Ribble Valley Borough Council  
Housing & Development Control

Application no: **3/2021/0276**

Address: **High Trees Longsight Road Clayton Le Dale BB2 7JA**

Proposal: **Regularisation of unauthorised stables, feed store, domestic garage, riding arena, new boundary wall/fence/hedge and alteration to accesses**

Proposed Site Plan

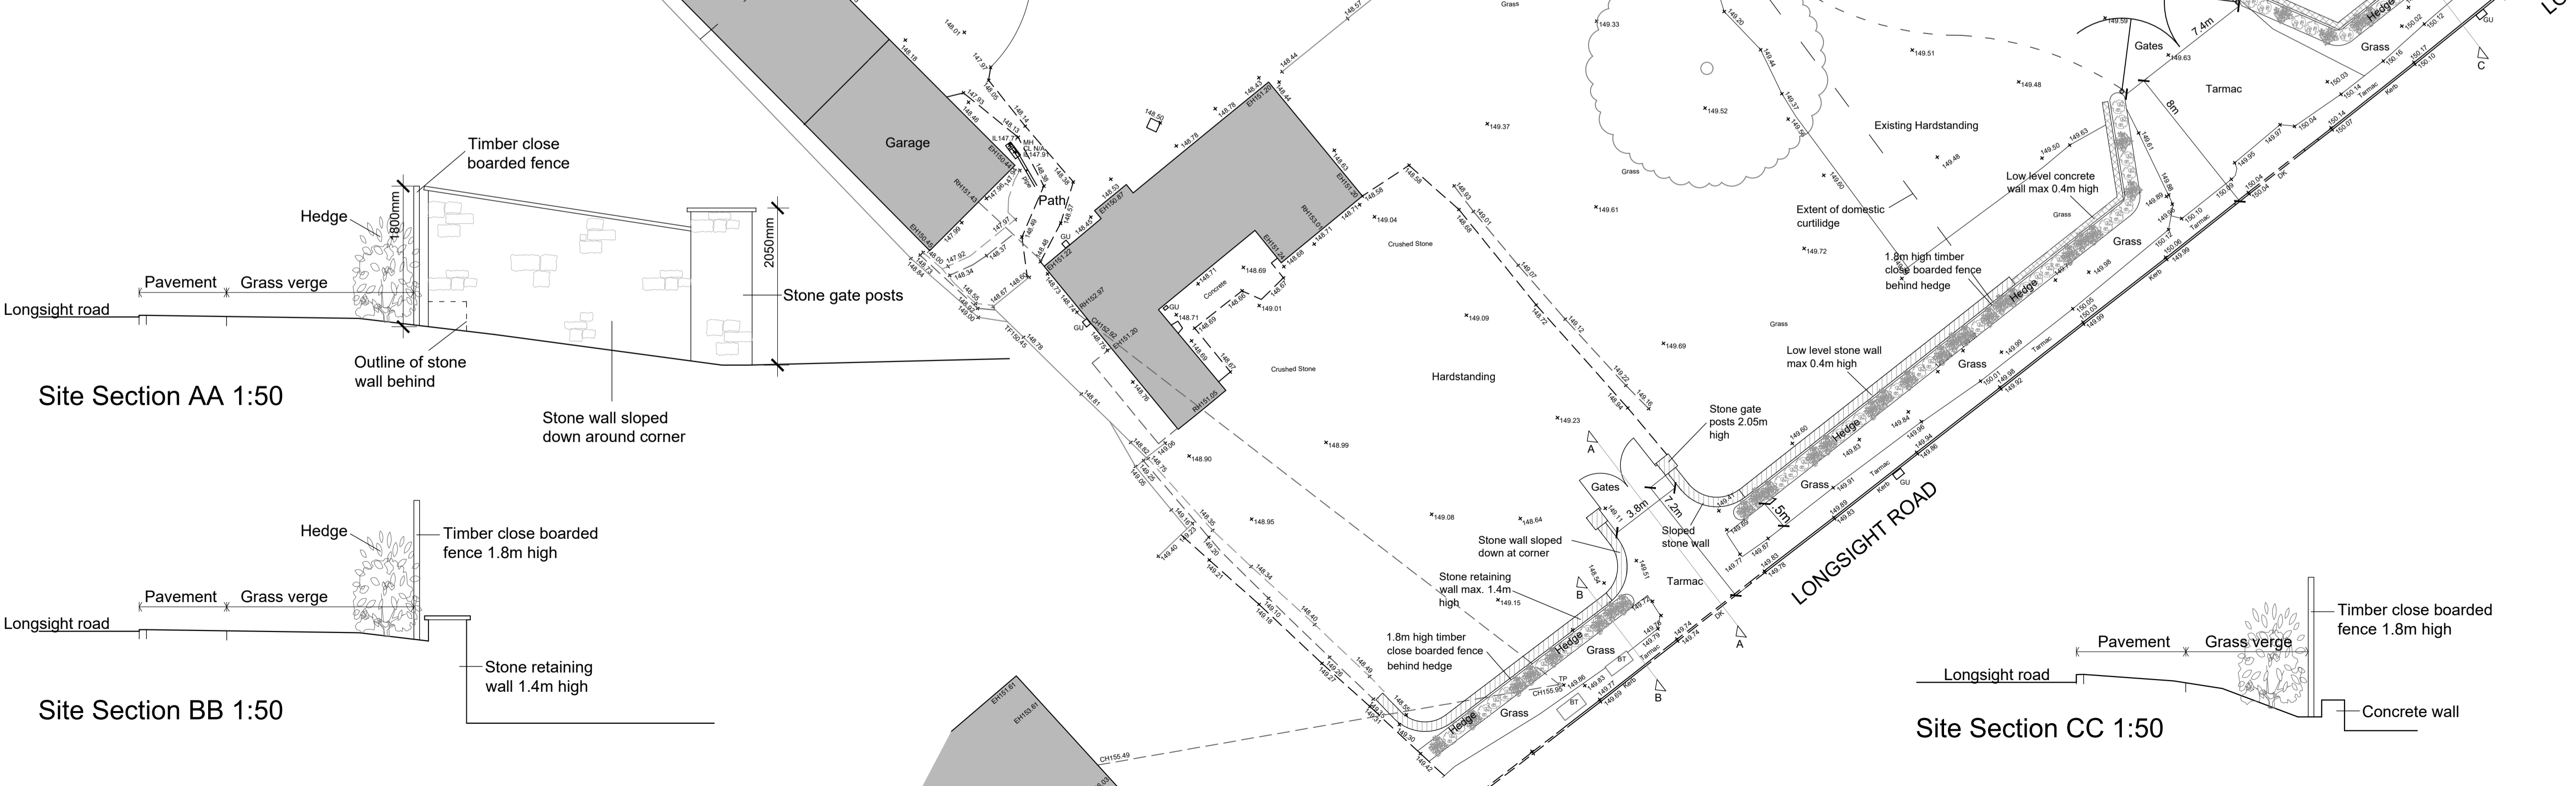
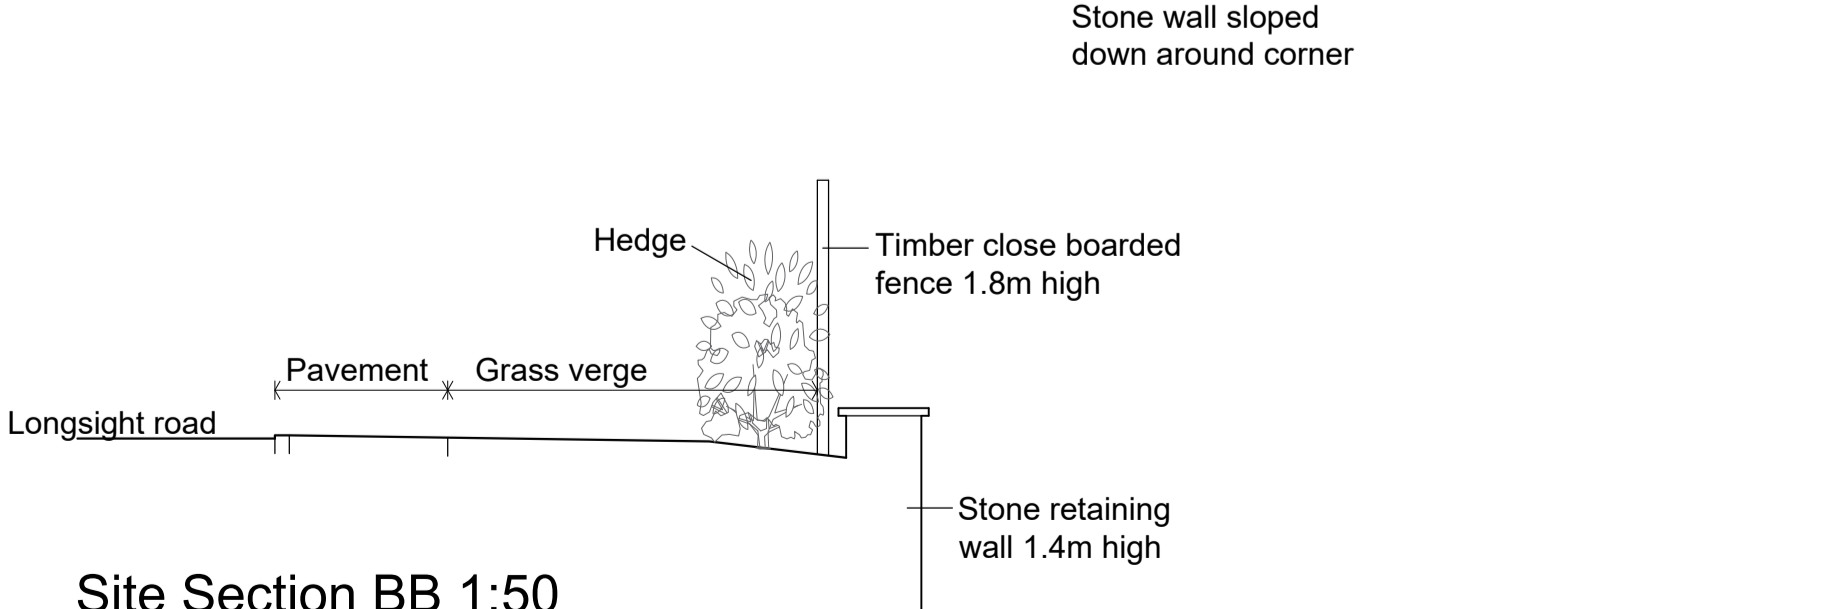
The proposed domestic access point will provide a 3.2m wide entrance, with internally opening gates positioned 7.2m from the carriageway. The existing arrangement will see one access point being stopped up and as such the existing vehicular dropped crossing point, serving the redundant access will need to be reduced in size to serve only the neighbouring access point and that part of the footway will need to be brought back up to full footway height.

The proposed agricultural access point will provide a 7.4m wide entrance, with internally opening gates positioned 8m from the carriageway. The proposed agricultural access is configured to provide a wider entrance off Longsight Road and the existing vehicular dropped crossing point, serving the agricultural access will need to be increased to match the full width of the entrance as the boundary walls are off-

set to that of the 7.4m wide entrance. This of course is expected to provide ease of manoeuvrability to larger vehicles accessing the stables, storage building and riding arena, which further details of this will be required to determine the level of expected traffic flow to and from the development site.

The submitted documents do not provide clarity over the expected vehicles or number of vehicles that will visit the development site. It is also not clear whether the development site would be private or commercial, all of which is a requirement in determining the proposed agricultural access points suitability.

There is also one flood light being proposed for the menage, although the location of this has not been applied to the plans.

Visibility splays for the proposed access points need to be applied to the plans whilst also demonstrating how the neighbouring access points will not be affected by the proposal.

Dimensions for the footway and service verge will also need to be applied to the plans and clearance dimensions from the carriageway to the proposed new hedge need to be applied to the proposed site plan in sections AA, BB and CC.
